**Planning Department
Transportation Development Services Section**

**Re: Albuquerque Heights Seventh Day Adventist Church, 4920 Wyoming Blvd
As-Built Information Concerns**
Engineer's Stamp dated 6-22-13 (F20-D021)
Certification dated 4-07-14

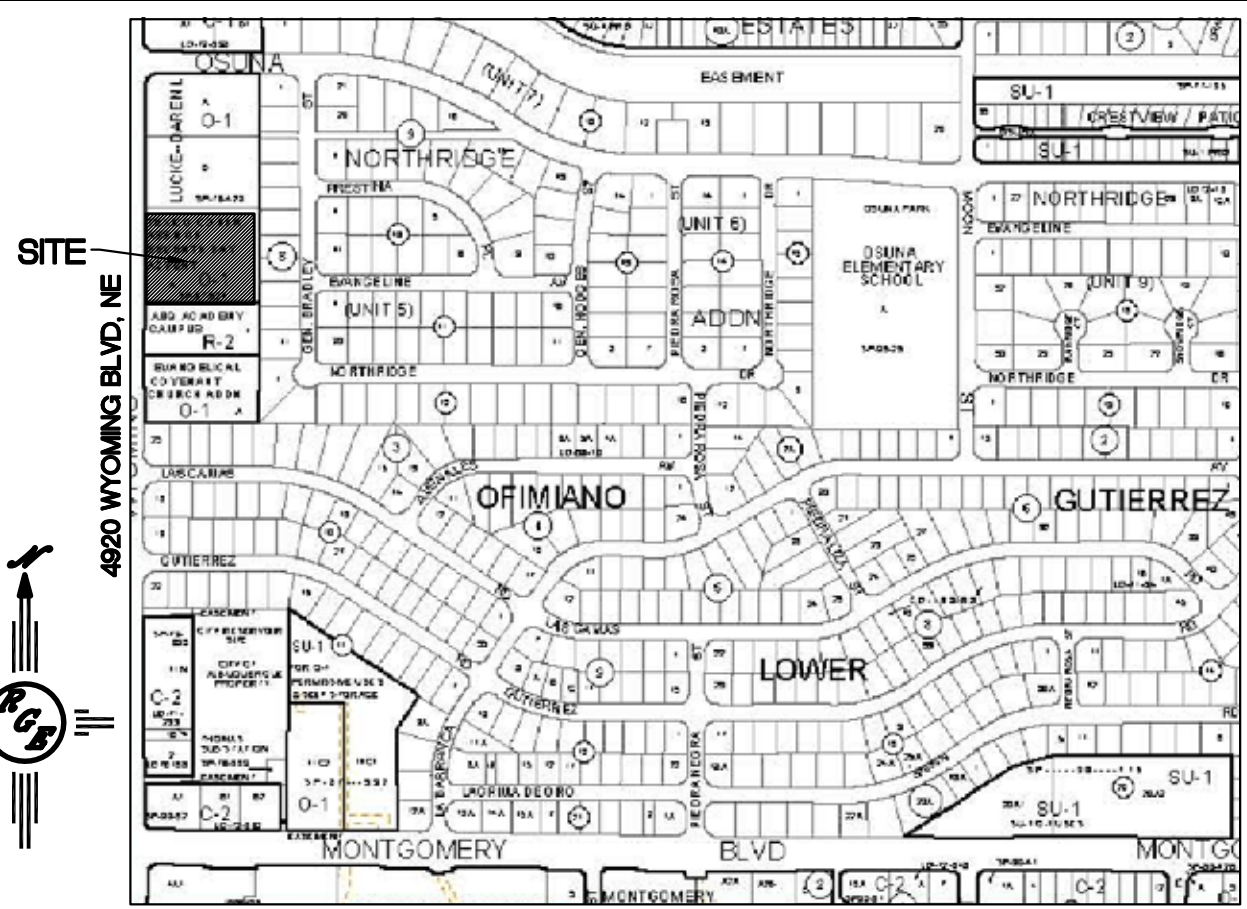
Please note that the grade change at the pedestrian walkway from the right-of-way on Wyoming Blvd. exceeds the maximum allowed. We suggest adding a landing to the pedestrian walkway to ensure an ADA accessible walkway from the Public Right-of-Way.
